Planning Application BE/60/15/PL

In the light of the significant alterations and amendments regarding this application since 1st August 2015 please accept the as a further objection to the proposals in addition to my original objection of 27th May 2015.

**EAST ELEVATION**  
**(1:100)**

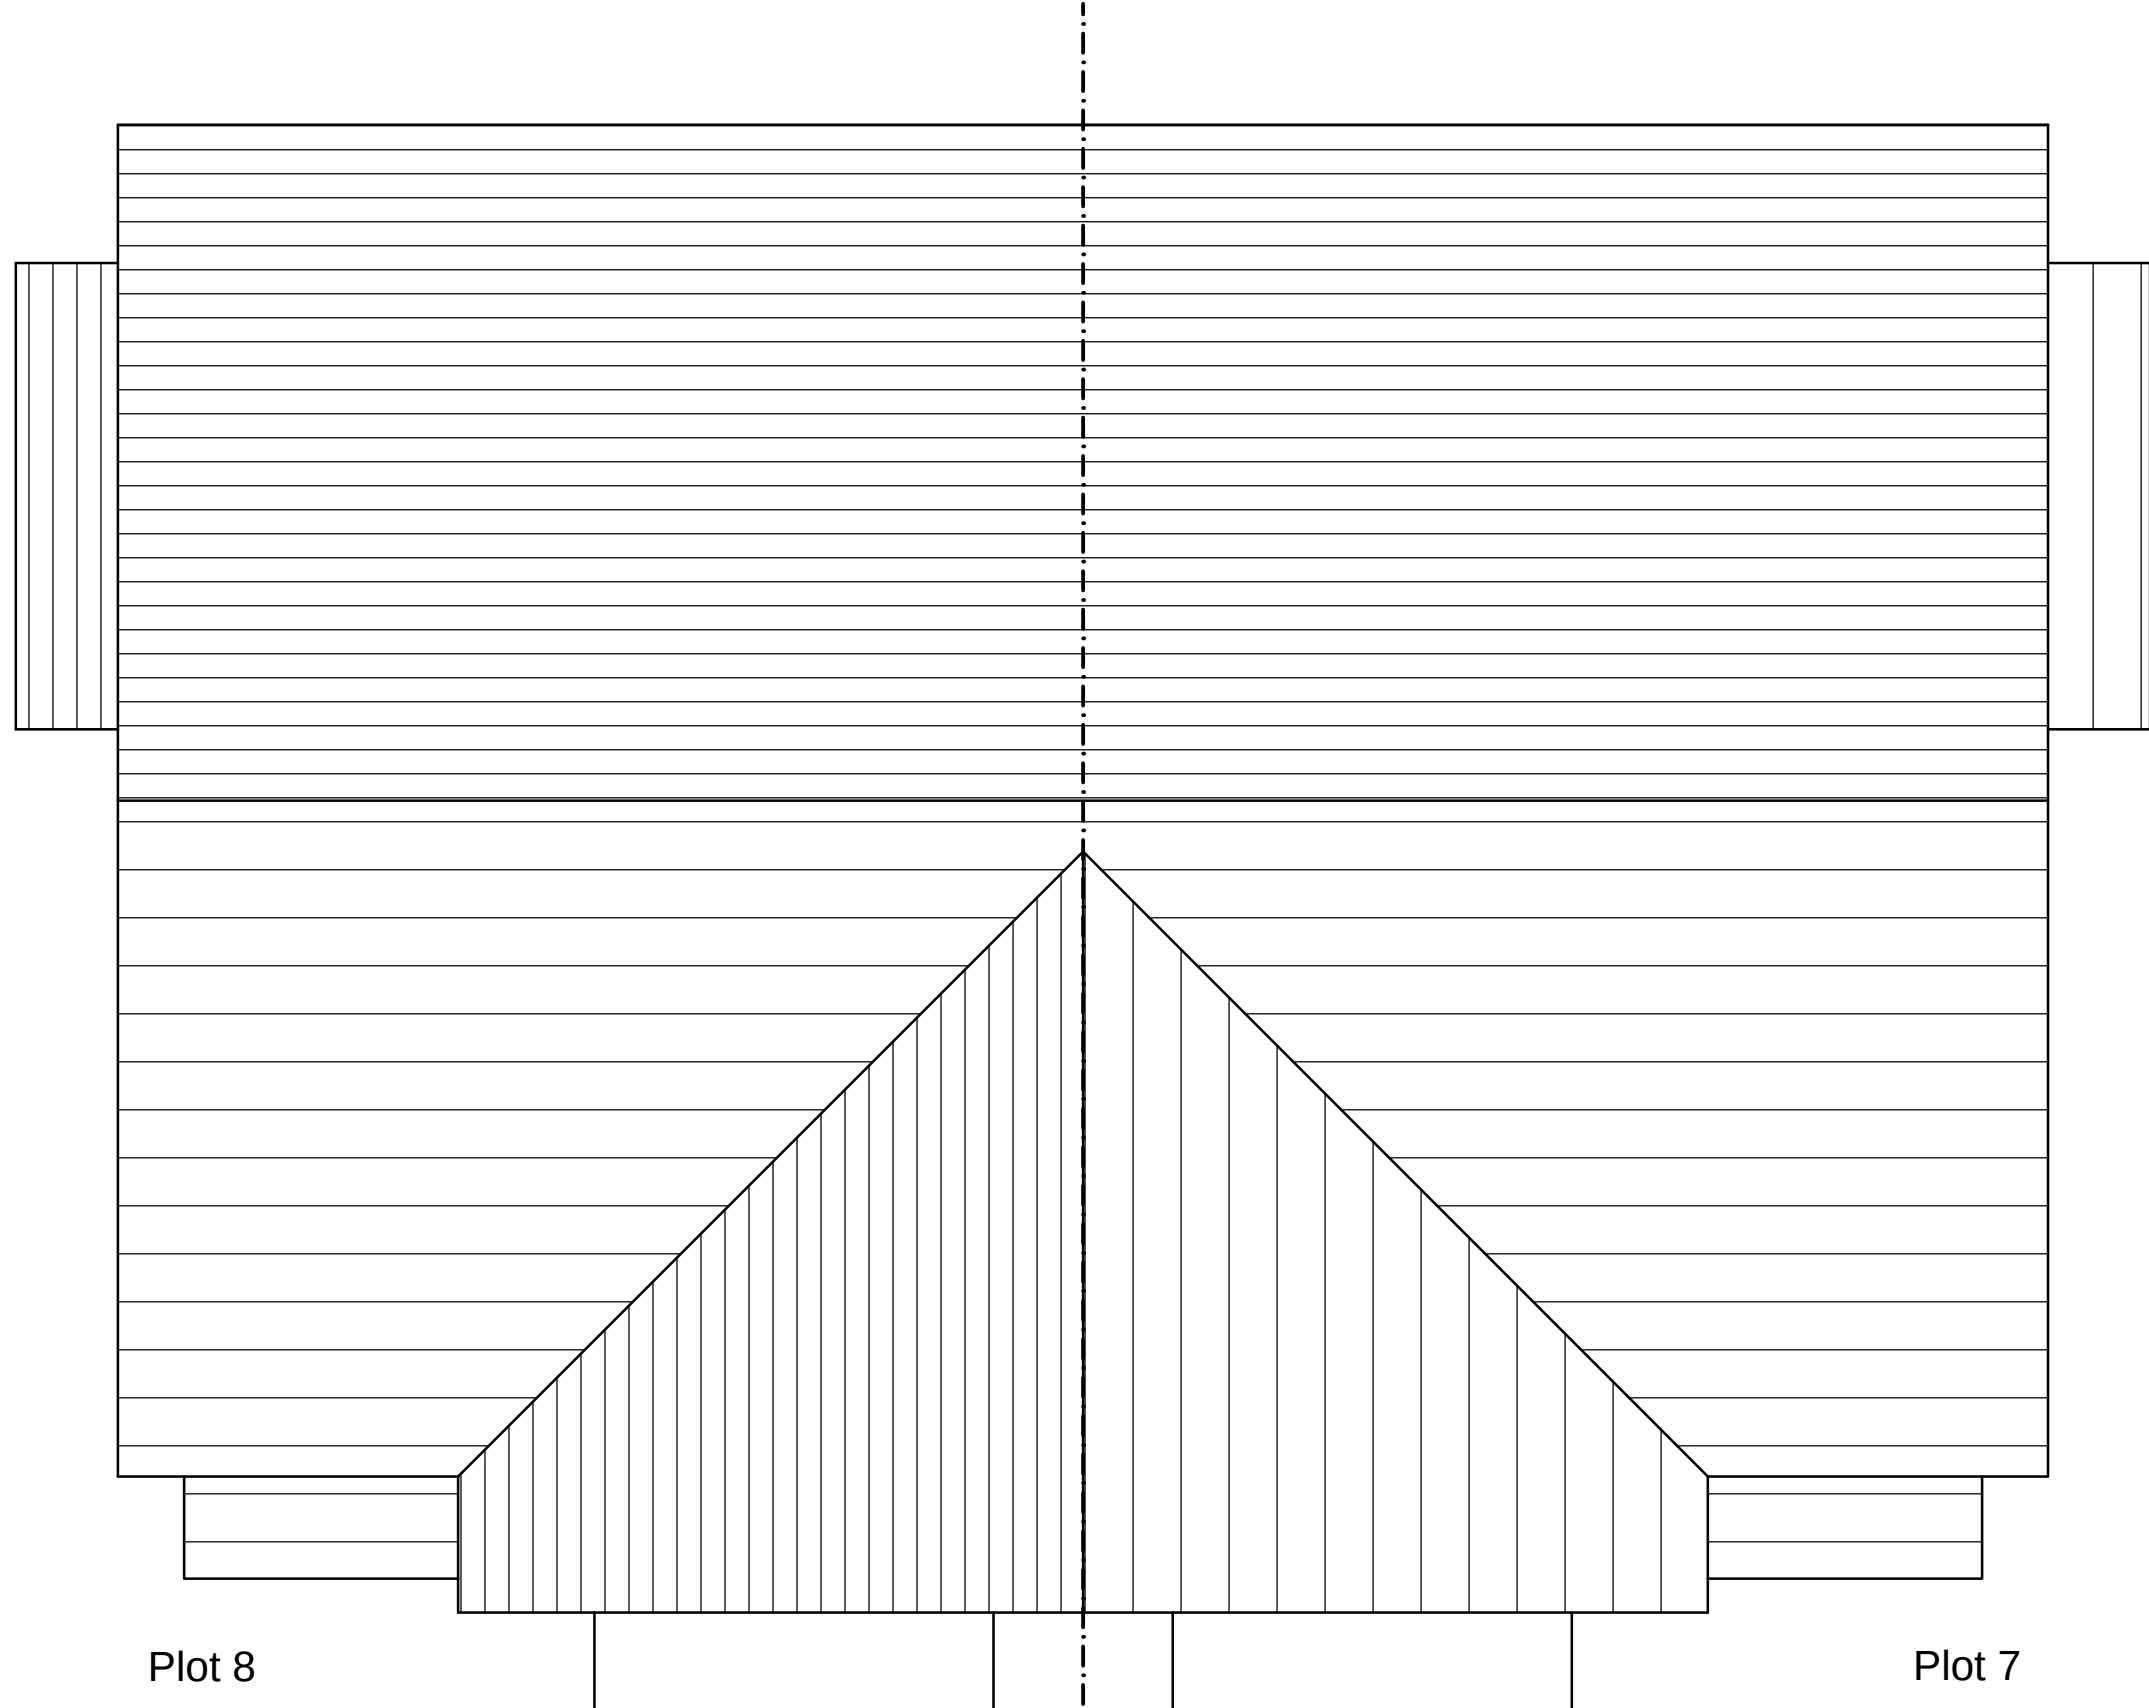
- The first floor windows comprising bedroom3, landing and bathroom of plot 8 overlook existing numbers 15 & 17. These properties are occupied by the vulnerable elderly and a young family. The windows are unneighbourly, directly compromise the privacy of these residents and would form an unsatisfactory backland development which would harm the privacy and quiet enjoyment of these neighbouring properties.

- The applicants also seek to use part of the drainage ditch to build the garages to plots 7& 8. Without those garages there is insufficient provision of parking to plots 7& 8 in contravention of the national guidance and putting increased pressure on the access road.
